Rezoning Transportation Analysis

Petition Number: 2020-068

General Location Identifier: Tax ID. 17514688

Date	Description
05-18-20	First Review
06-28-20	Second Review
09-22-20	Third Review (LJensen)
12-28-20	Fourth Review (LJensen)
02-23-21	Fifth Review (LJensen)

SCHEMATIC SITE PLAN
PETITION # 2020-068
FOR
HEDGEAMORE - MONTFORD PARK
CHARLOTTE, NORTH CAROLINA 28209

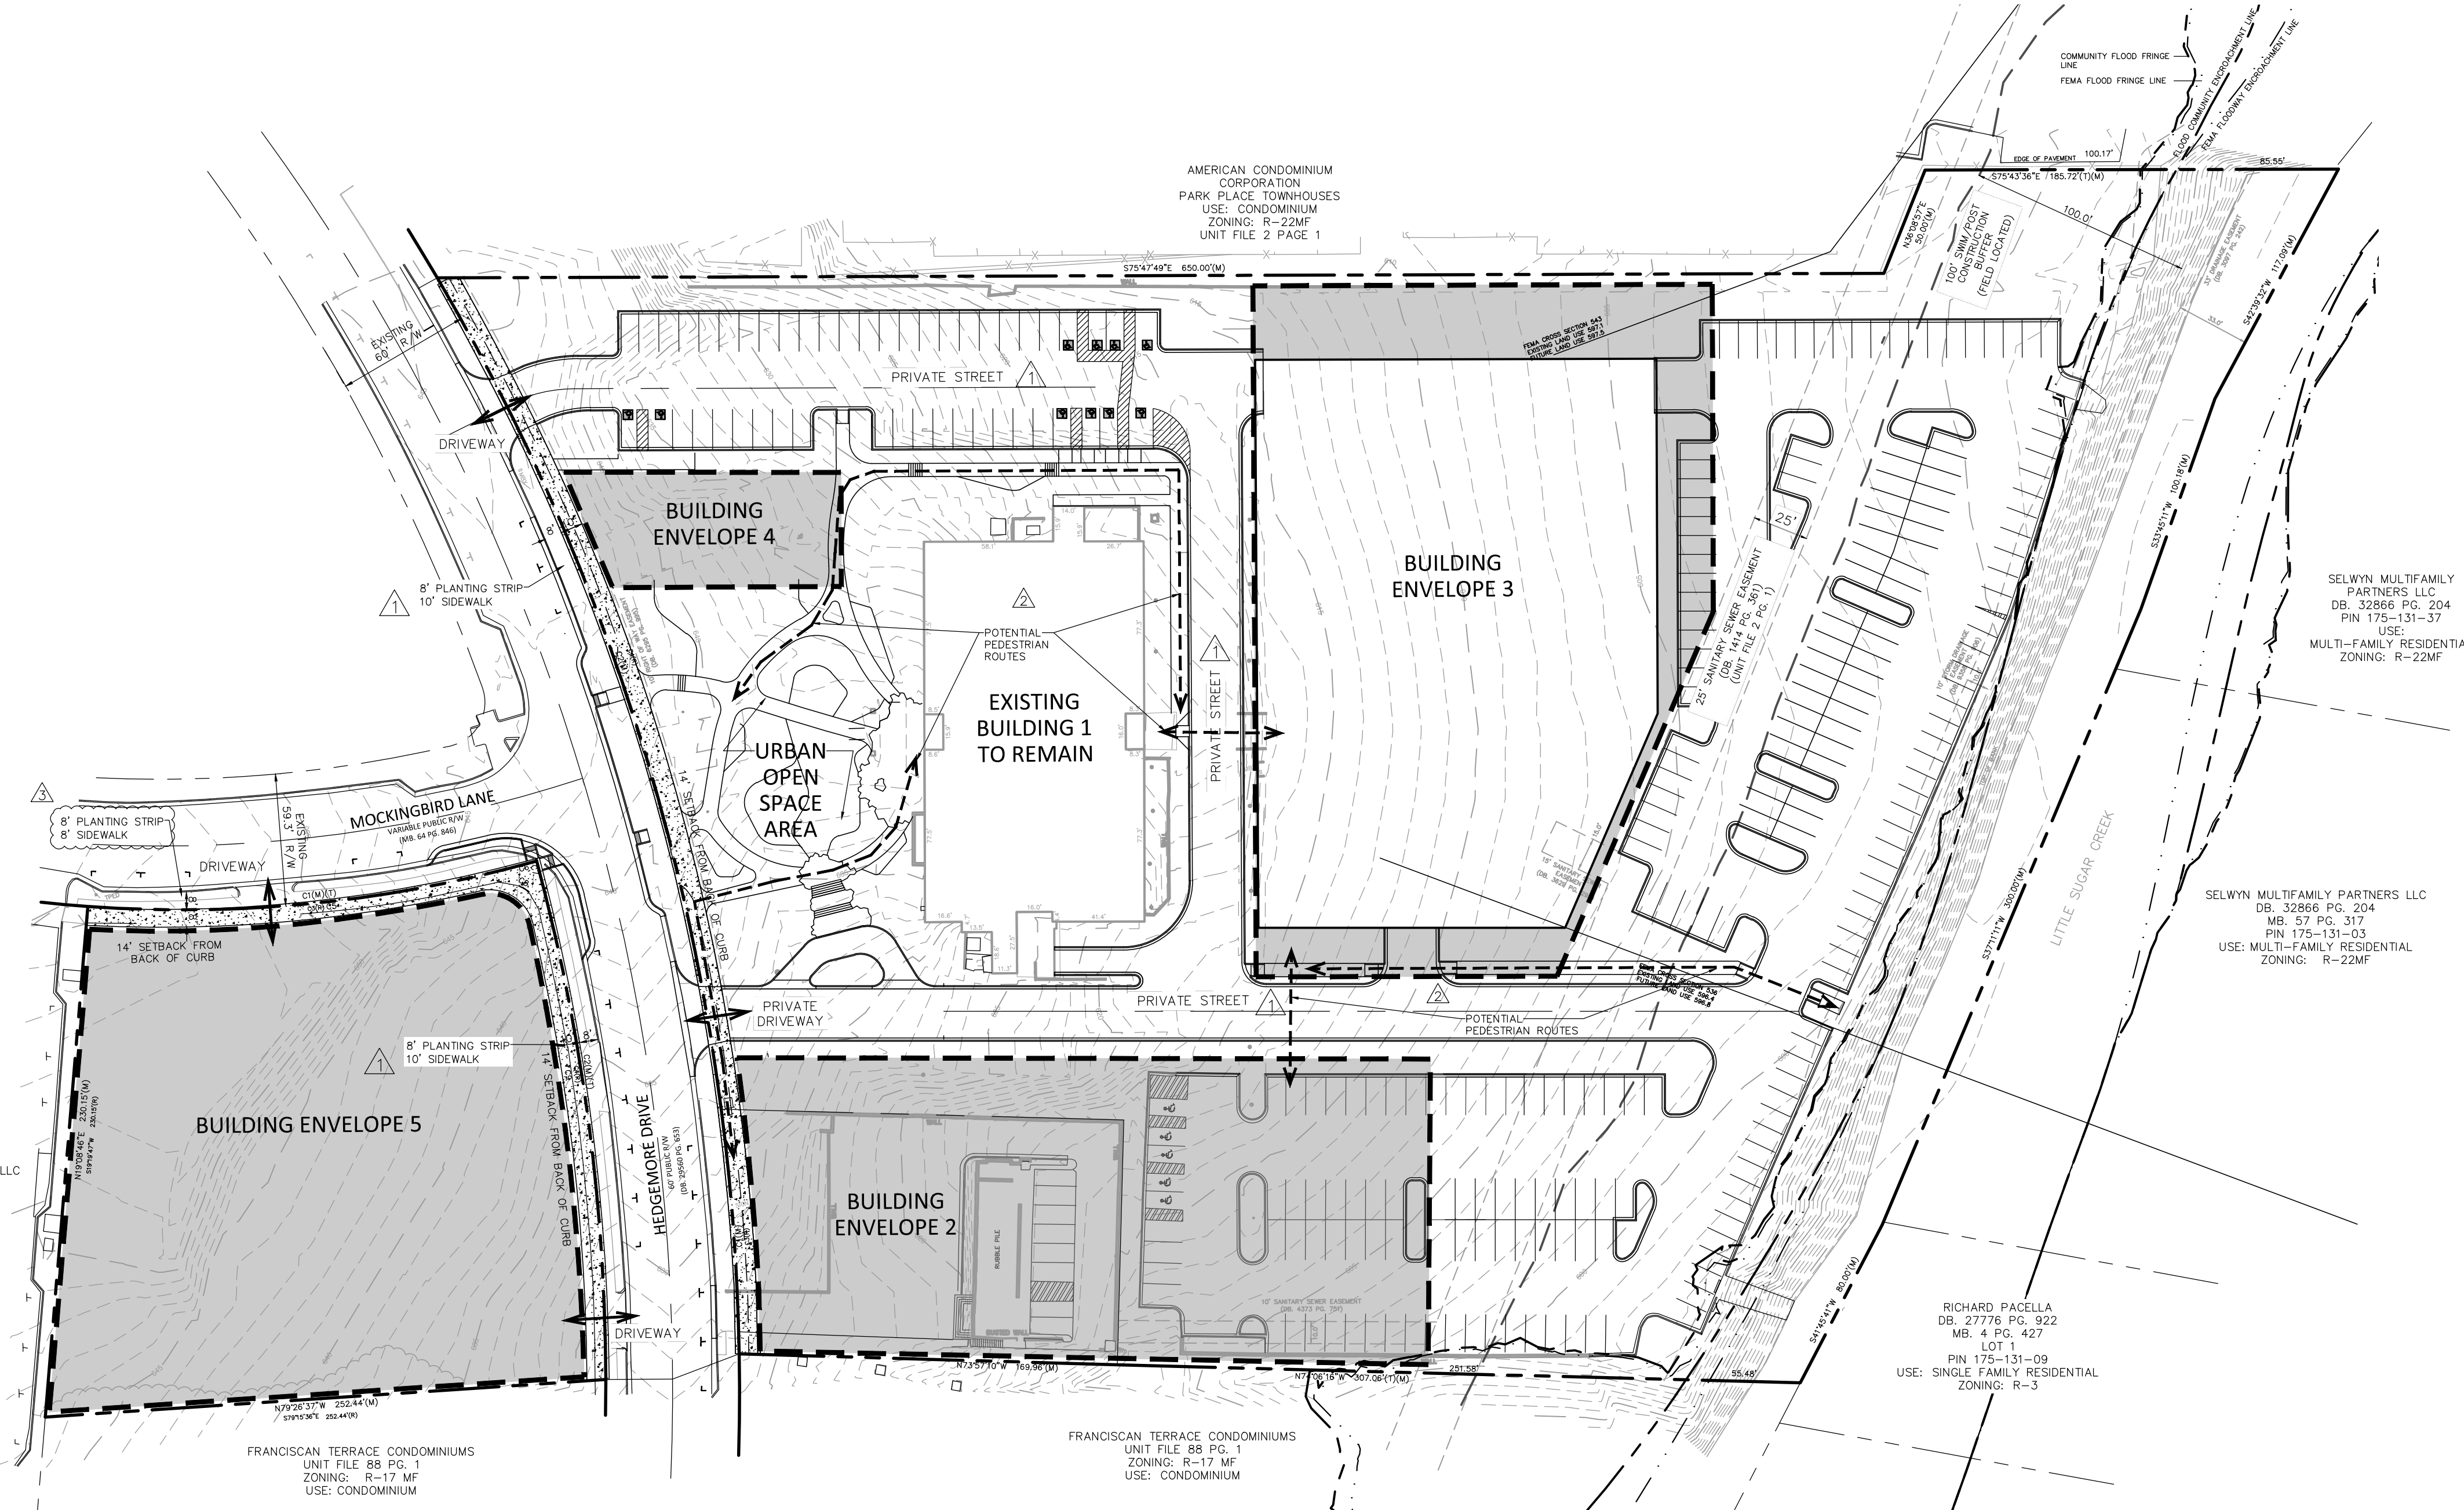
8. **New Comment: (02/23/2021 – in reference to Approved TIS)** Revise note V. Transportation b. 1. to read "Install appropriate signal head to allow for permitted-protected northbound and southbound approach for left-turn phasing on Park Road;"
